# **A1 in Northumberland: Morpeth to Ellingham**

**Scheme Number: TR010059**

## **Applicant's Response to Relevant Representations**

<b>Regulation Reference:</b>	APFP Regulation Rule 8(1)(c)
<b>Planning Inspectorate Scheme Reference</b>	TR010059
<b>Application Document Reference</b>	TR010059/6.7
<b>Author:</b>	A1 in Northumberland: Morpeth to Ellingham Project Team, Highways England

| Sustainability                                                                    |  | Status                                       |            | Project Title                          |            |

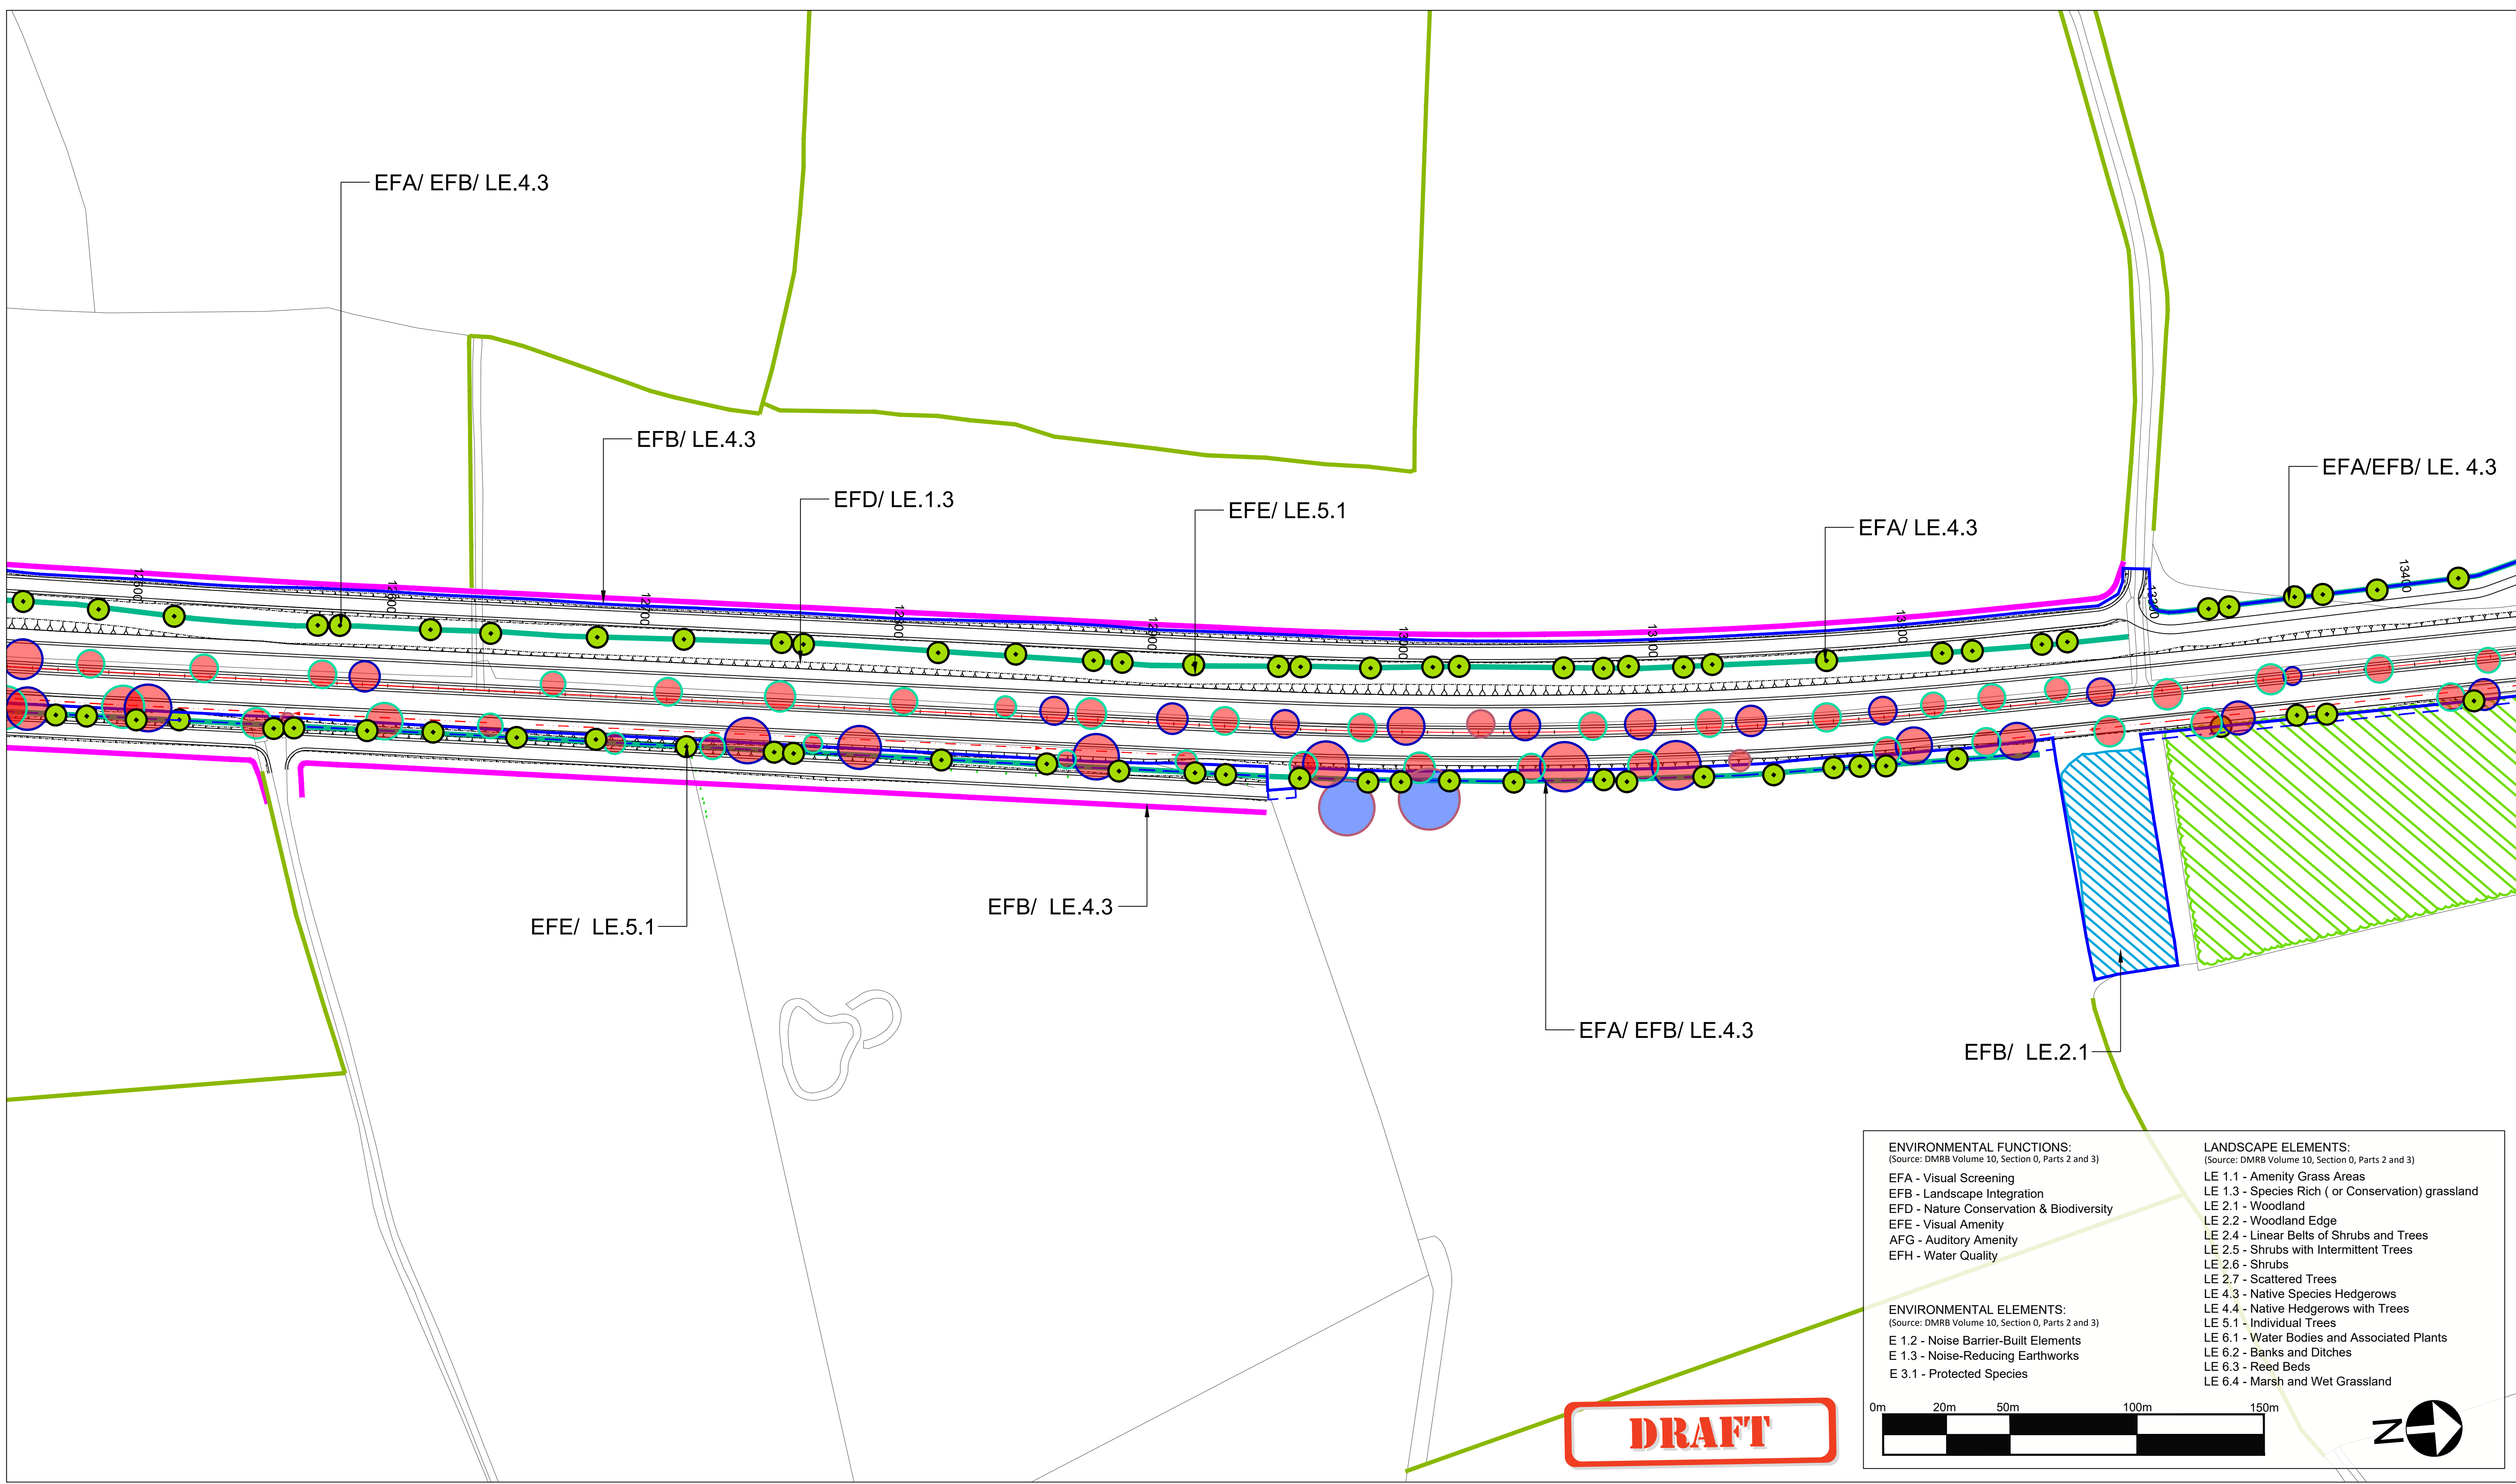
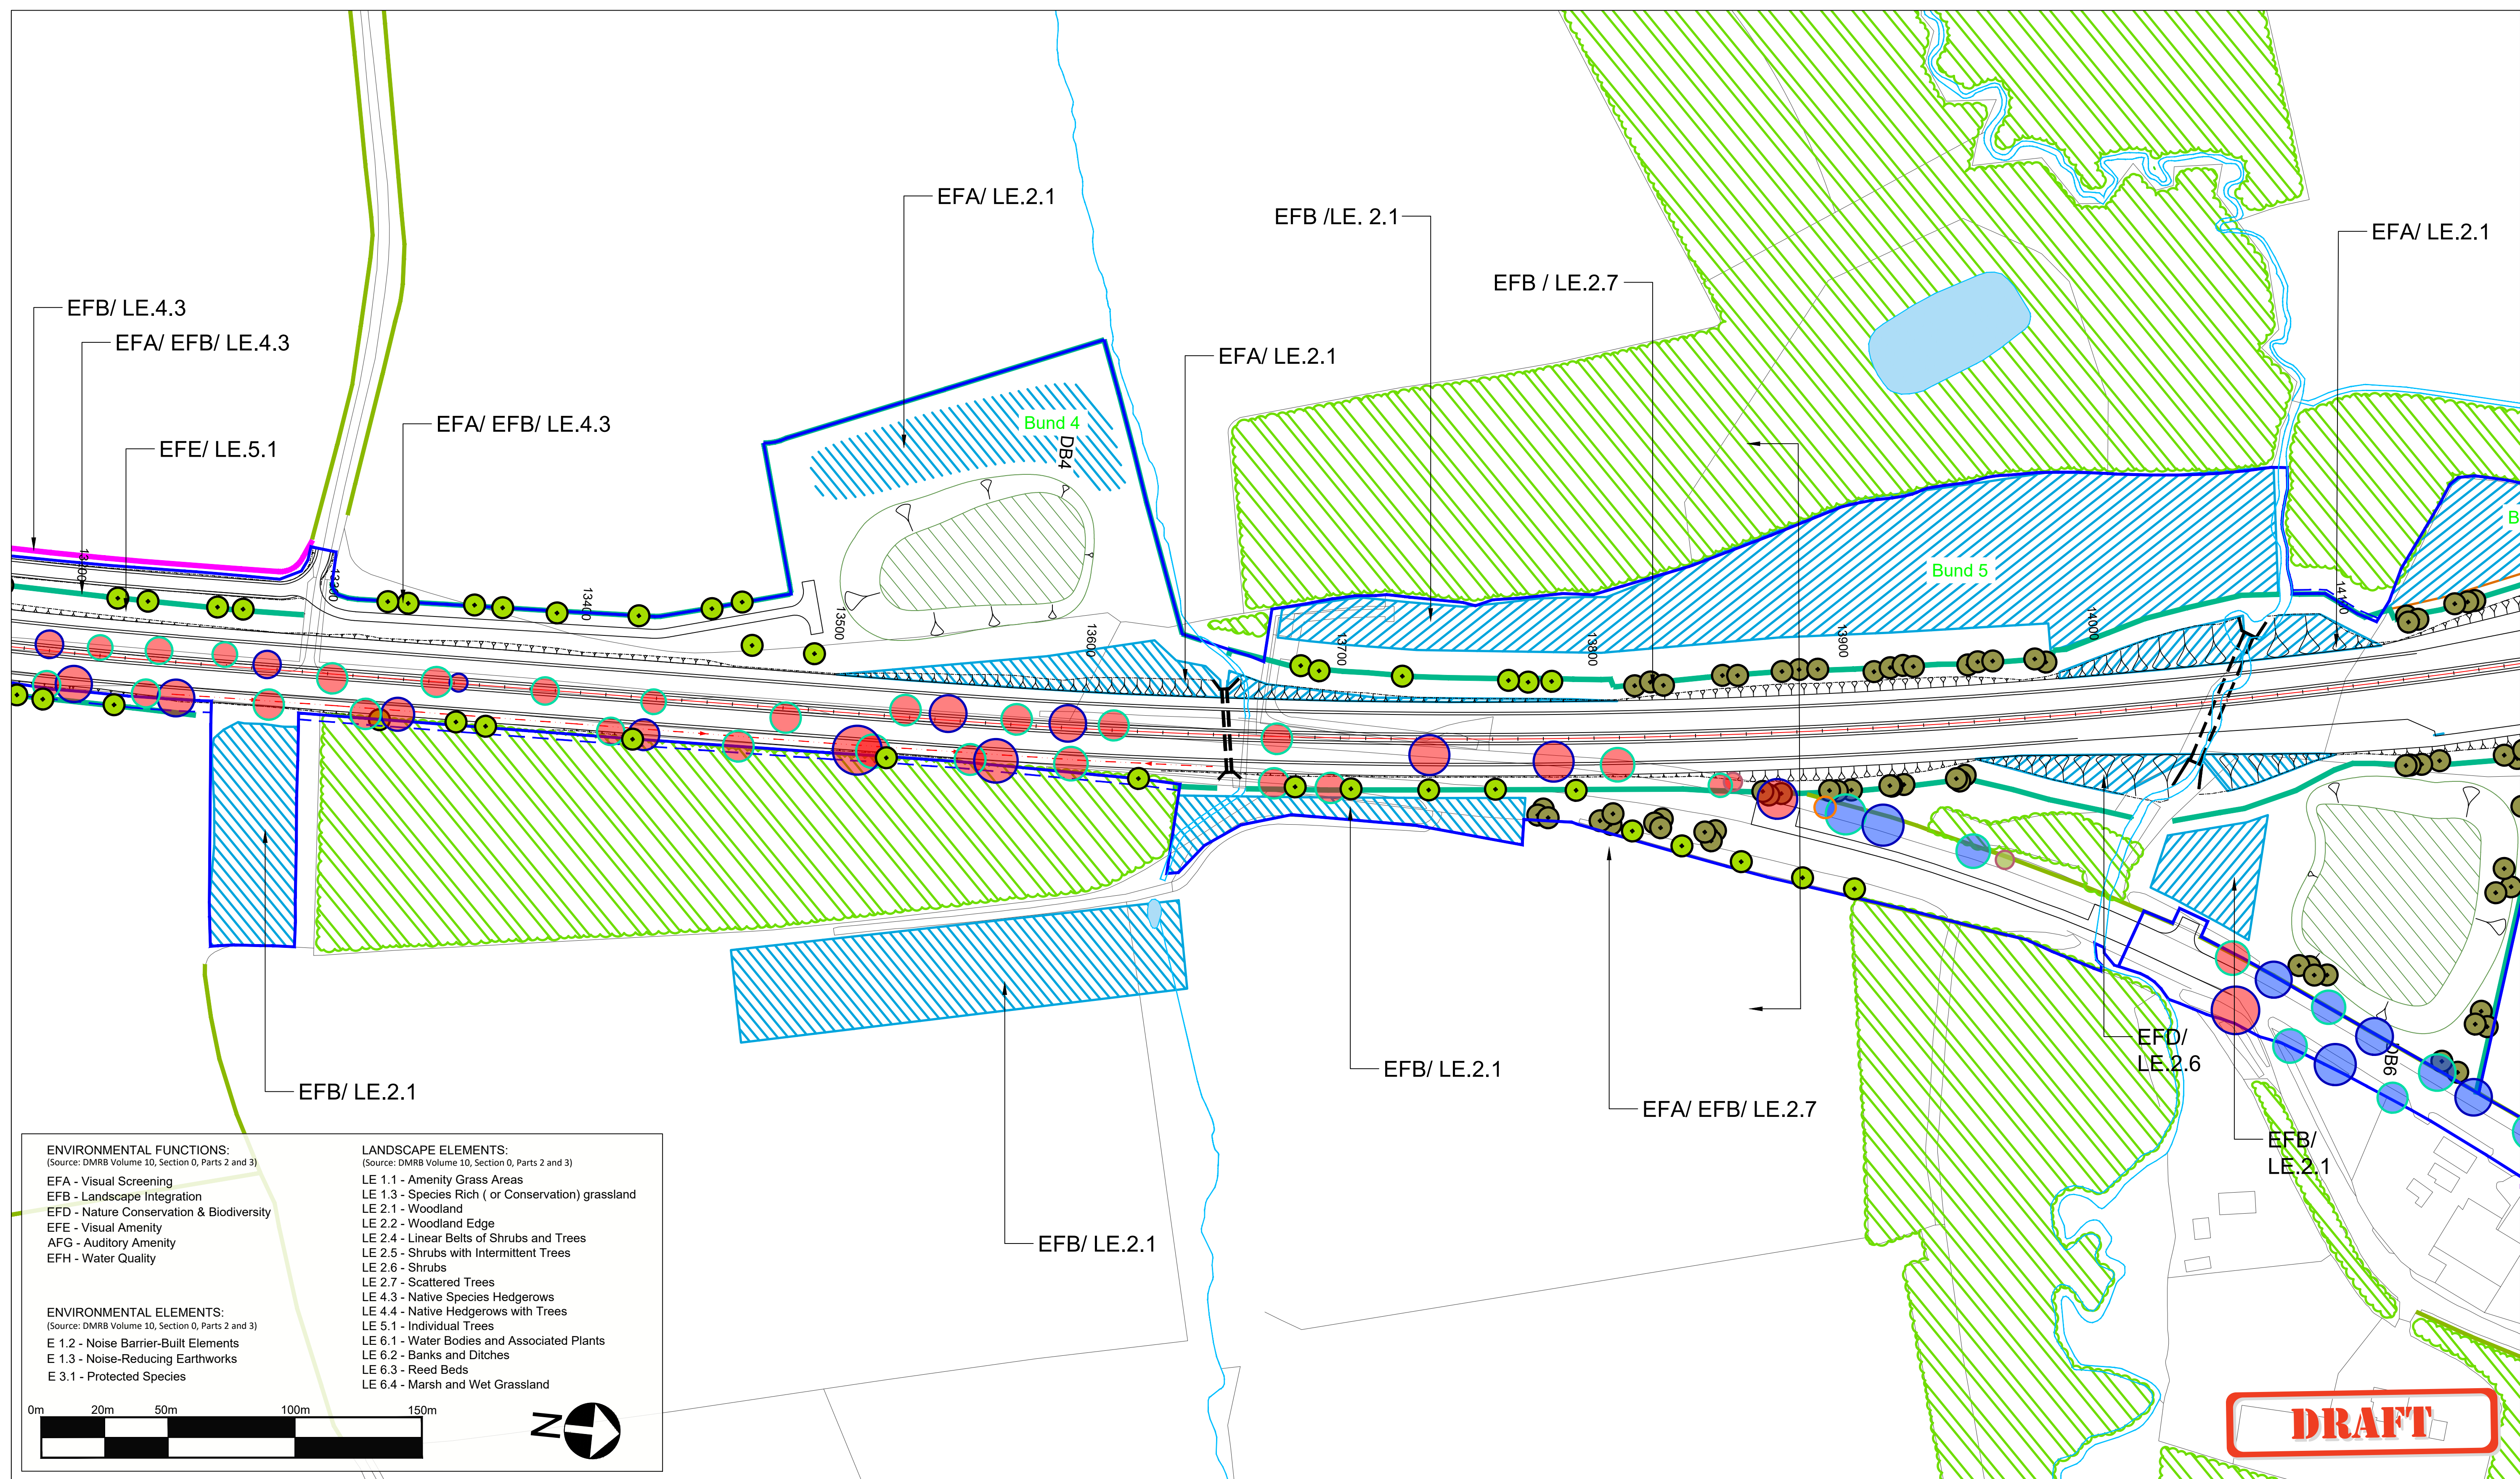
1.1.23	<p>The replacement Coronation Avenue is a token gesture, consisting of trees spaced roughly every 100m. This avenue plays an important role in retaining a rural, well vegetated character through this section of the route and the LVIA is quite clear about the local importance of the Avenue as a landscape feature and the sparse nature of the replacement compared to what is removed is not explained or justified in the application.</p>	<ol style="list-style-type: none"> <li>1. In paragraph 7.8.10 of Chapter 7: Landscape and Visual, Part A [APP-044] it is acknowledged that 187 no. of the 300 no. trees that form the Coronation Avenue would be removed by the Scheme. Figure 7.8: Landscape Mitigation Masterplan Part A, [APP-095] identifies the indicative location of the replacement trees, at regular intervals along the extent of the A1 where the presence of trees planted as part of the Coronation Avenue currently exist, totalling 38no. As has been identified above, the Landscape design as set out in Figure 7.8: Landscape Mitigation Masterplan Part A, [APP-095] including any replacement vegetation and trees to restore the Coronation Avenue will be approved by the Secretary of State following consultation with NCC as per Requirement 5, Schedule 2 of the draft DCO [APP-014]. The Applicant has prepared a draft strategy for the replacement of trees along the Coronation Avenue, identifying the final number and spacings of the replacement trees that would be planted to restore the landscape feature, refer to Appendix LV.2 submitted at Deadline 1 in response</li> </ol>

Reference	Comment from Relevant Representation	Applicant's Response
		to ExA Written Question LV.1.8, having been discussed and agreed with NCC via email January 2021.
